Sydney Olympic Park - Site 13

Preferred Project Report - February 2010

Contents

West Elevation

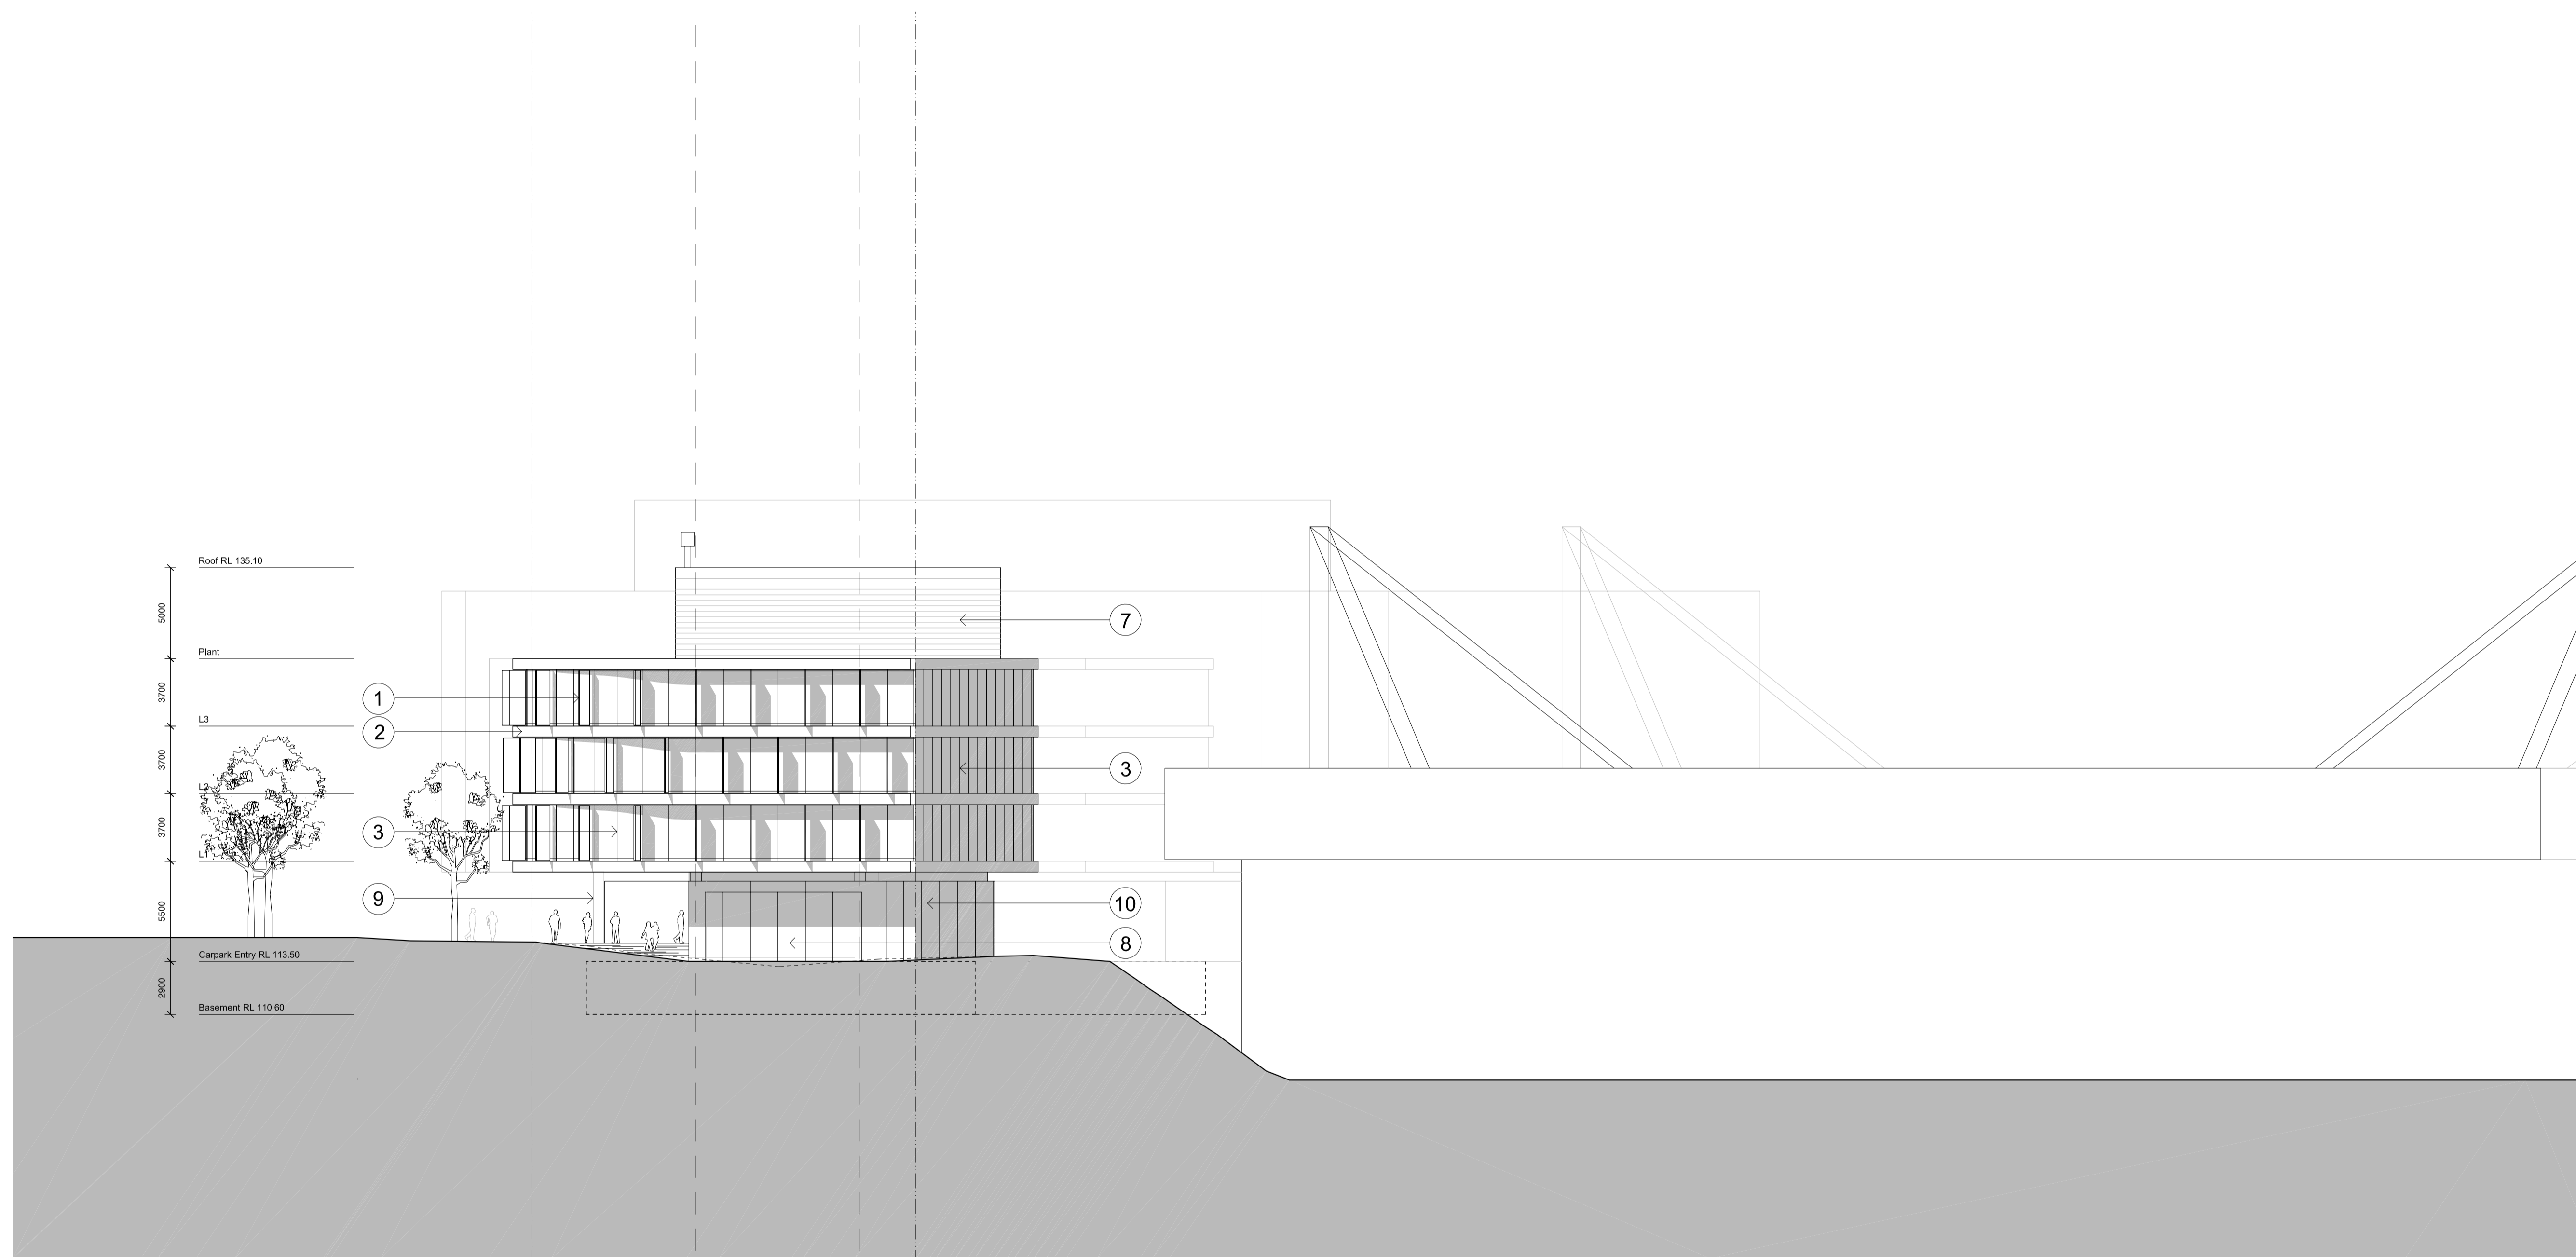
4.04 Image of plantroom louvres added to external finishes board
5.0	General	Refer to all plan and elevation drawings
		5.01 Structural grid amended
		5.02 Overall building set out on site amended in order to avoid projections over the boundary of more than 400mm

Sydney Olympic Park  
Site 13  
L06  
Roof Plan

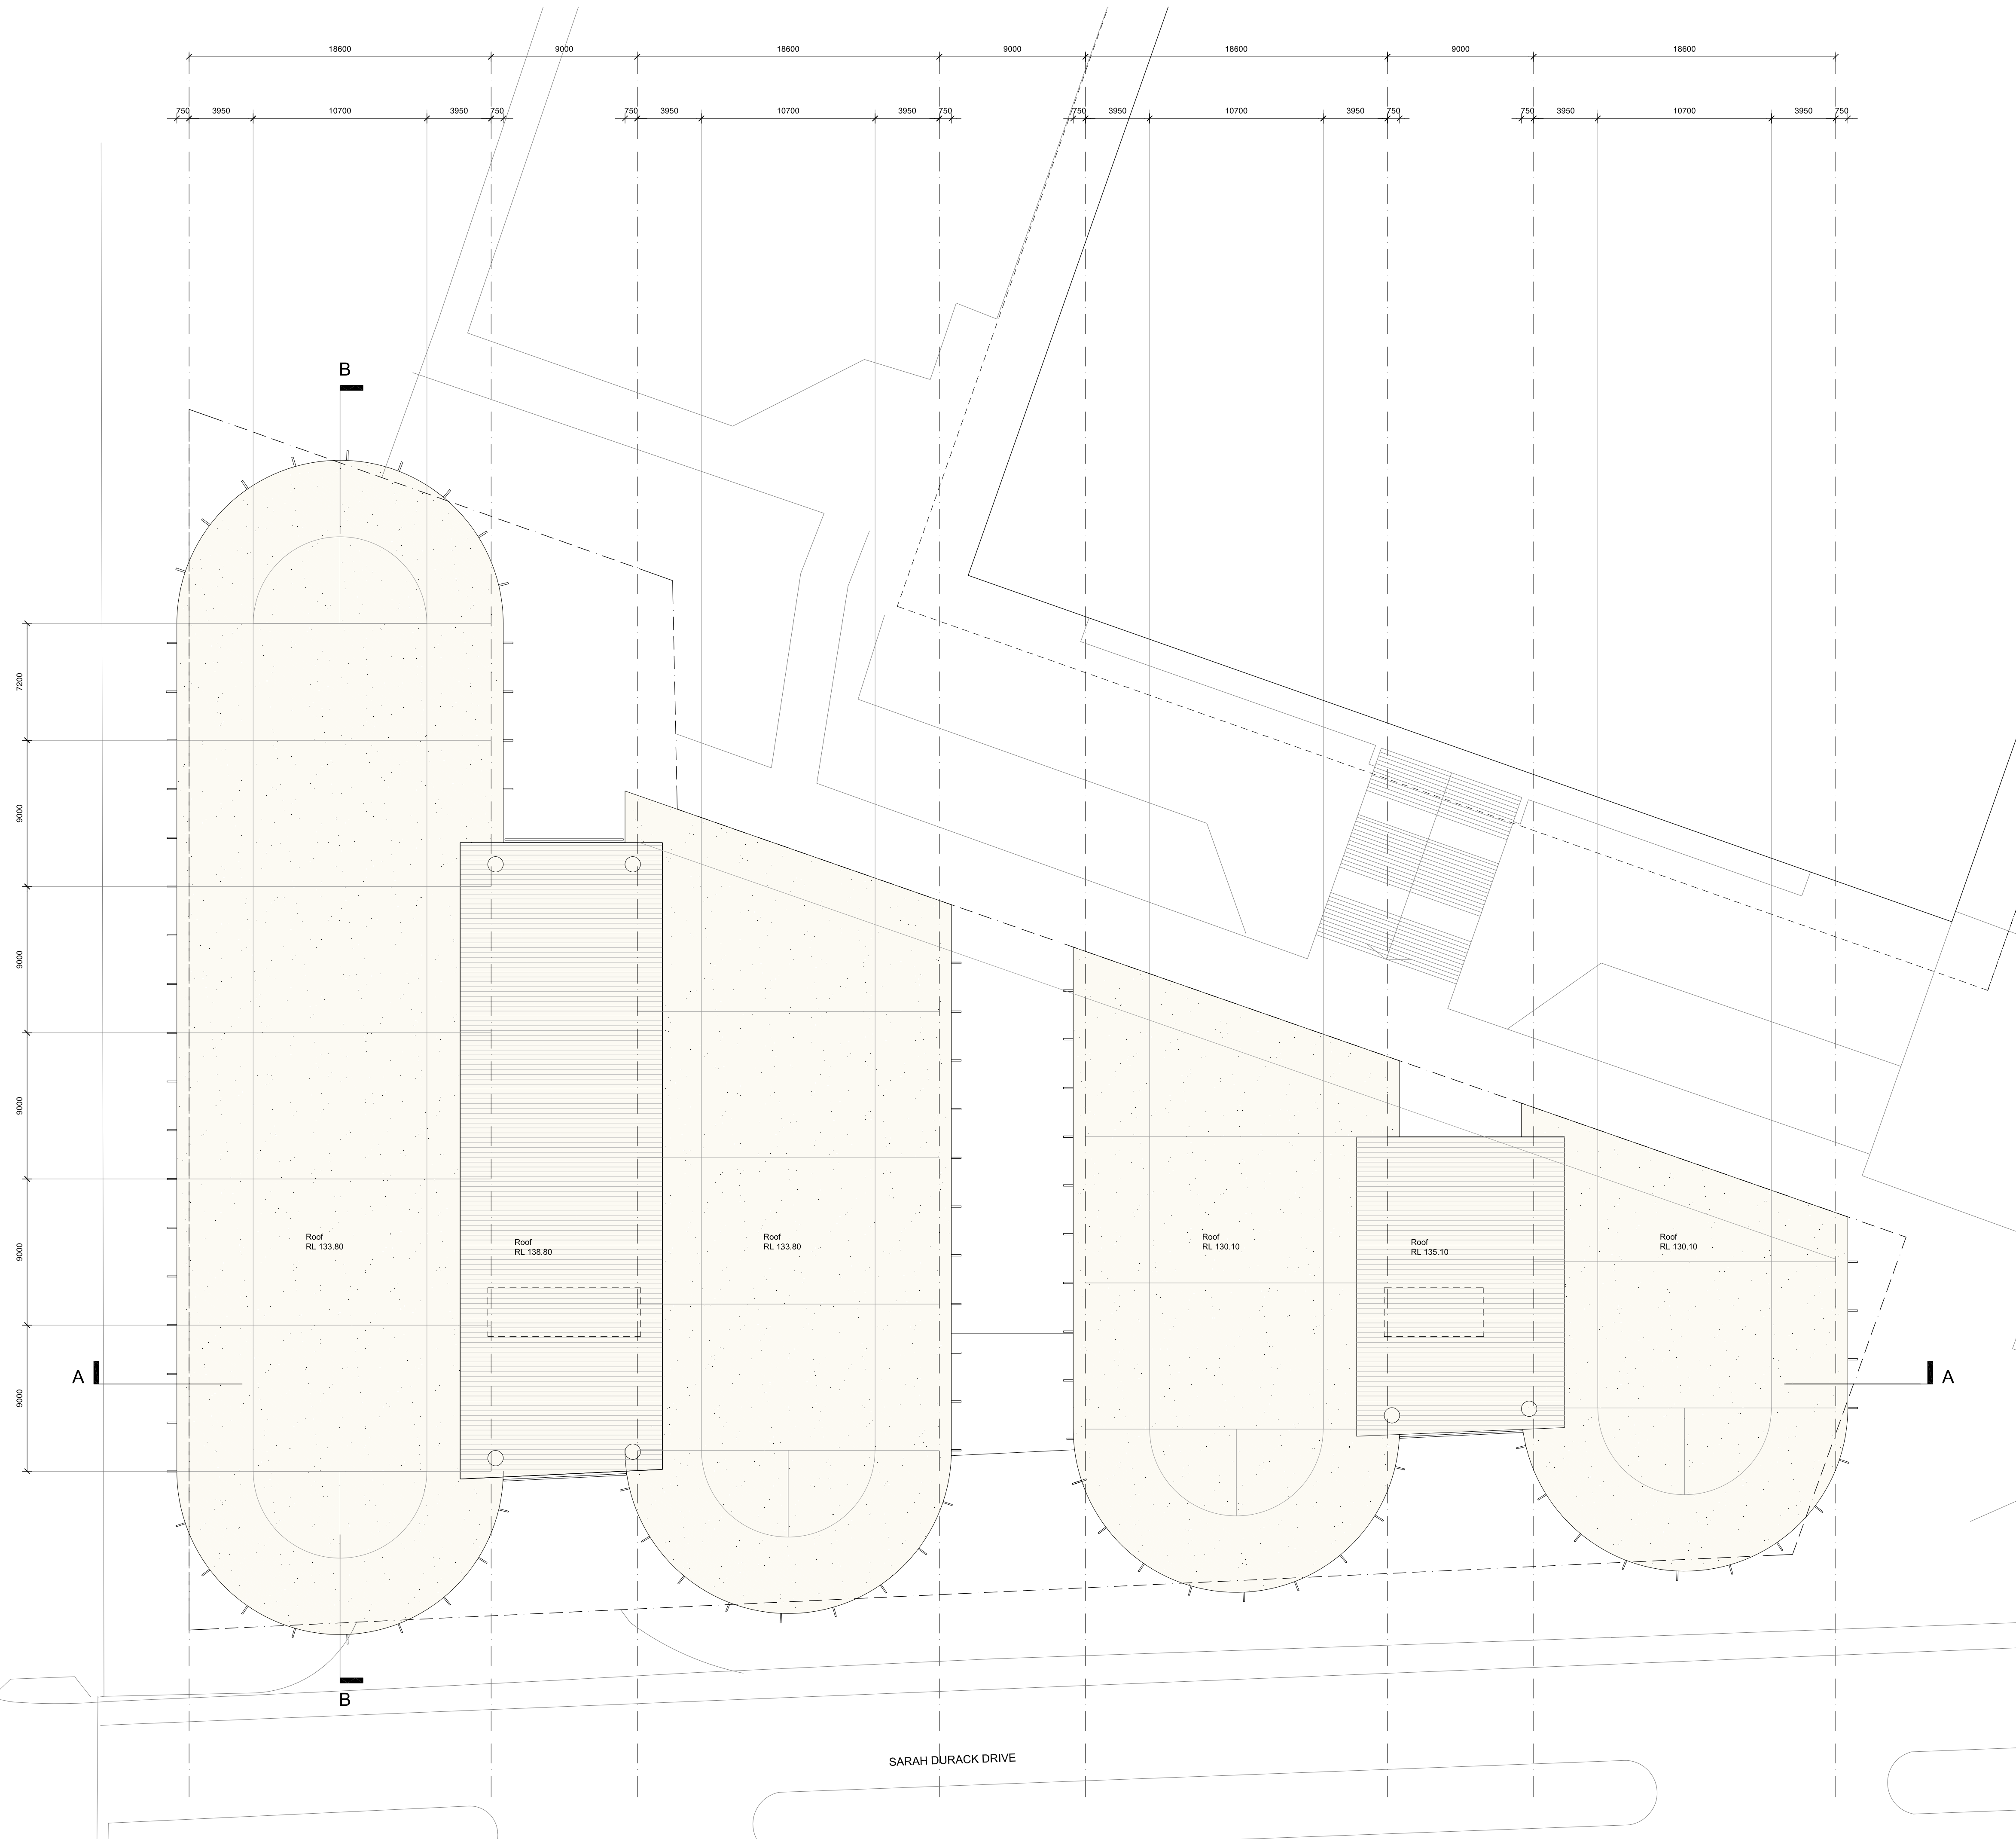
4.01 Increased area of roof plant room
		4.02 Deletion of natural ventilation chimneys
		4.03 Solid cladding AND louvers as cladding to roof plantroom instead of louvres only

Sydney Olympic Park Site 13
L01-L03
Typical Floor Plan

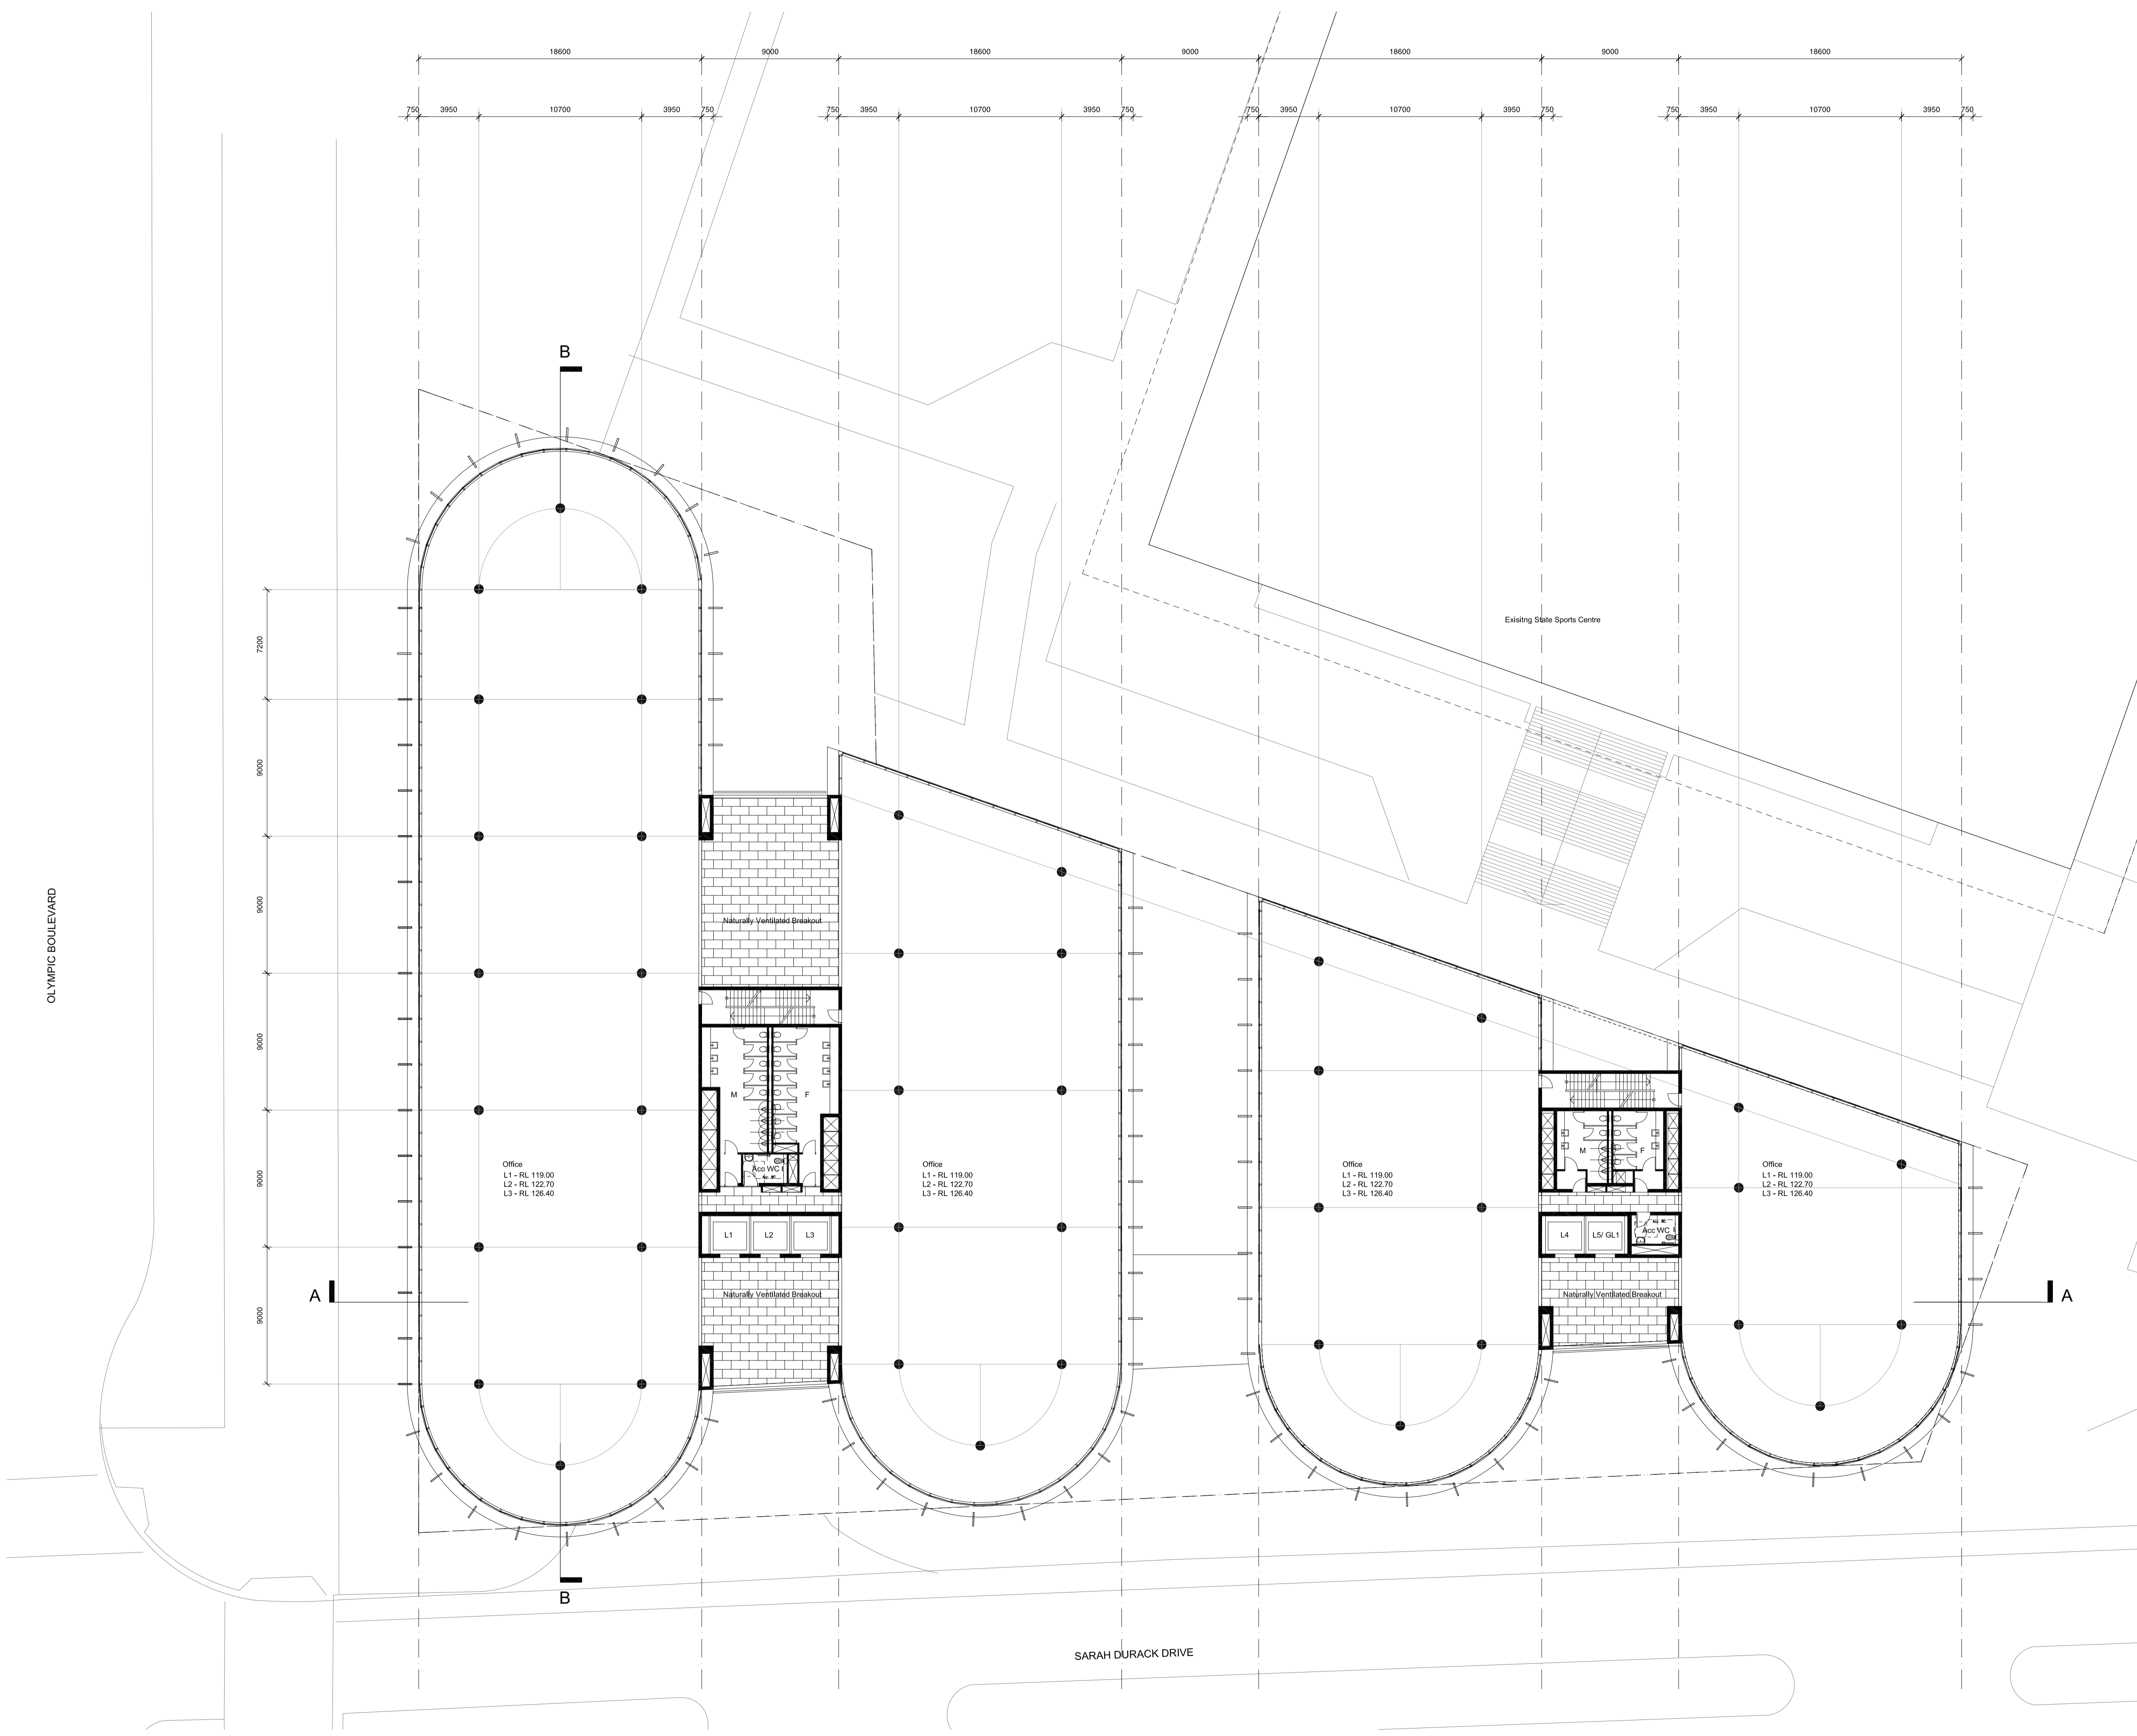
3.01 Reduced size of vertical aluminium fins (sunshades)
		3.02 Deleted internal partition walls between office floor plates and naturally ventilated spaces

3.03 Deleted ventilation shafts
		3.04 Reduced projection beyond site boundary (slabs within the boundary, sunshades protrude 400mm over the boundary)

3.05 Amended layout of shafts and bathrooms in building A + B cores
		3.06 Façade details have been developed beyond the state of documentation in DA report sketches

3.07 Floor finish to lift lobbies and break out amended
		3.08 Replacement of black anodised aluminium cladding to projecting slab edges by aluminium cladding coated in black PVF2
